# **AHP** design and heritage statement

application: Proposed single storey earth sheltered extension to form new kitchen annex

document nr: 22046DA-101-P01 – Richard Nicholson, Mill Farm Amended Proposal

date: 30 September 2025

title **Ground Floor Plan and Site Layout as Proposed**
 number **22046D-21-P06**
 scale **1 : 50**
 size **A1**

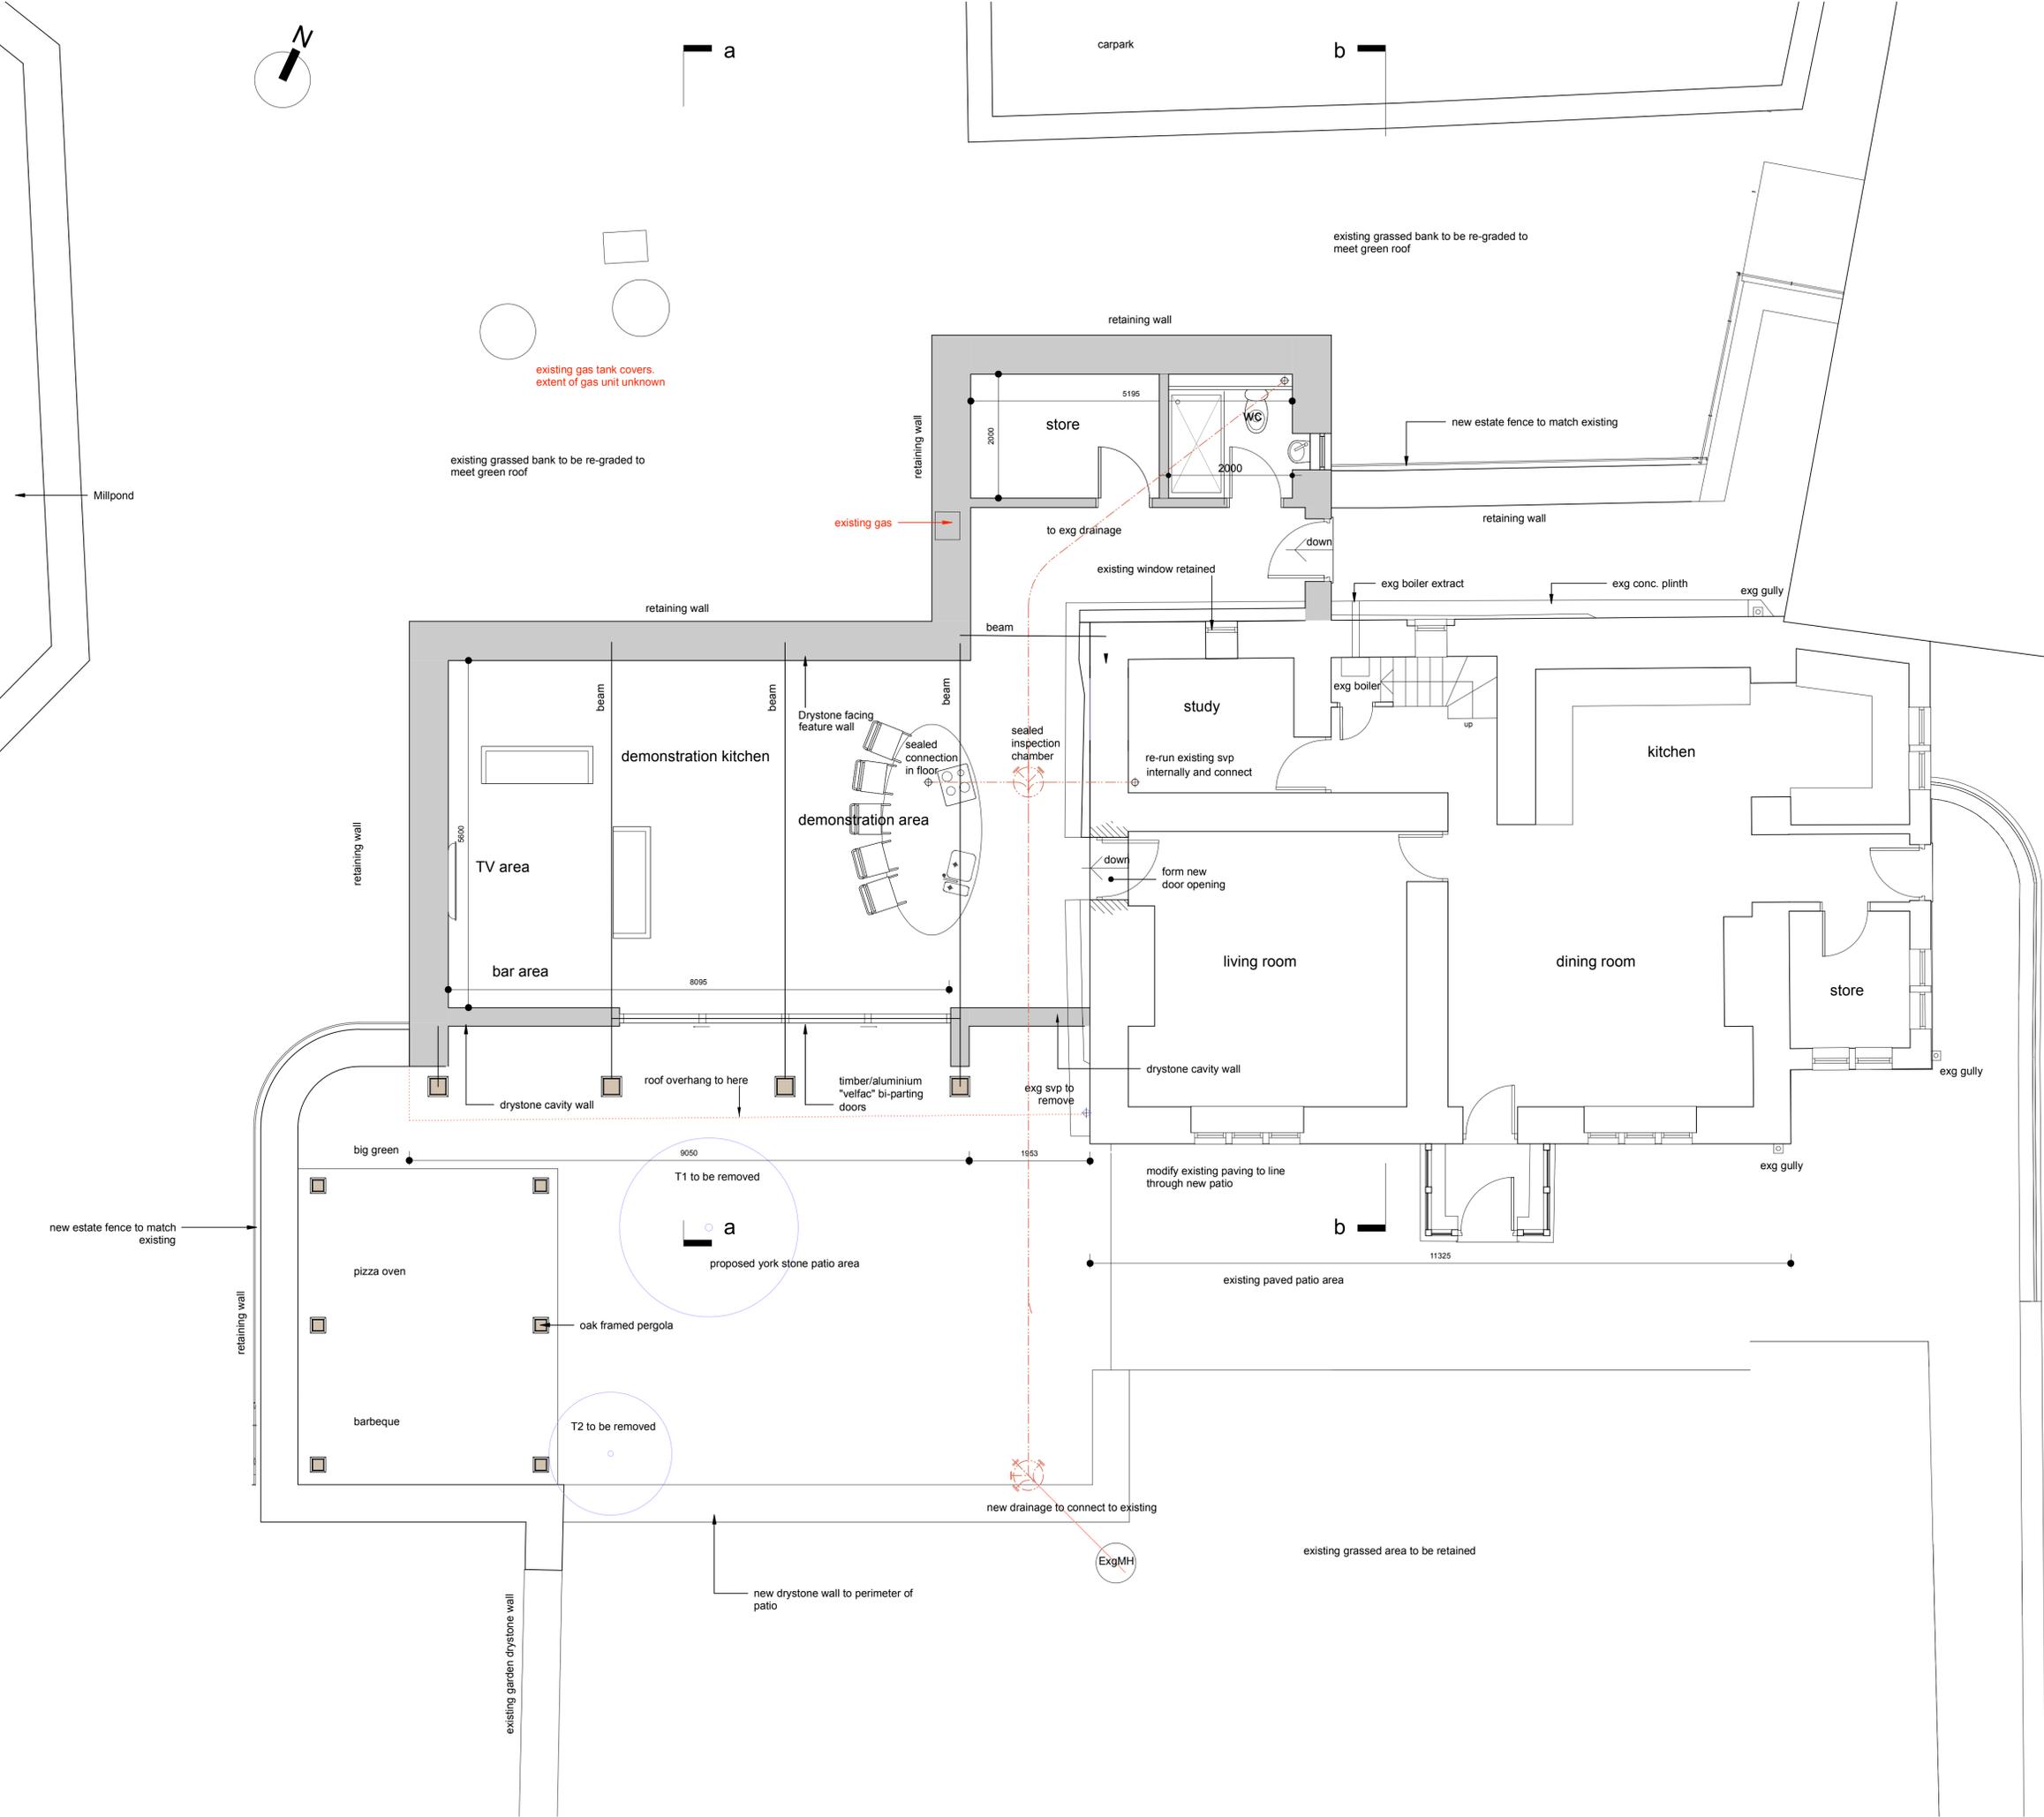
- Reconfiguration of internal partitions within the extension, resulting in fewer internal walls.
- Relocation of the shower room to a different part of the extension.
- Adjustment to the position of the door opening linking the extension to the existing house.

The internal changes within the new extension are minor and have no bearing on the historic fabric of the listed building. The key adjustment is the repositioning of the doorway linking the extension to the existing dwelling. In the approved scheme, the doorway connected through a smaller room; in the revised layout, the opening would provide direct access to the main living room, positioned discreetly to the side of the existing fireplace, the amount of historic fabric removed would be the same as it would in the approved scheme. The change of layout would retain the small room shown on our proposals drawing as a lobby, enabling our client to use this room as a study,

Reduction of internal partitions and relocation of the shower room occur wholly within the new extension and do not affect historic fabric.

The revised doorway position will provide a direct connection between the demonstration kitchen and the main living room, set to the side of the fireplace.

he relocation of the doorway requires only the creation of a modest opening in an existing wall; this will not result in the loss of any more significant fabric, than in the approved design.
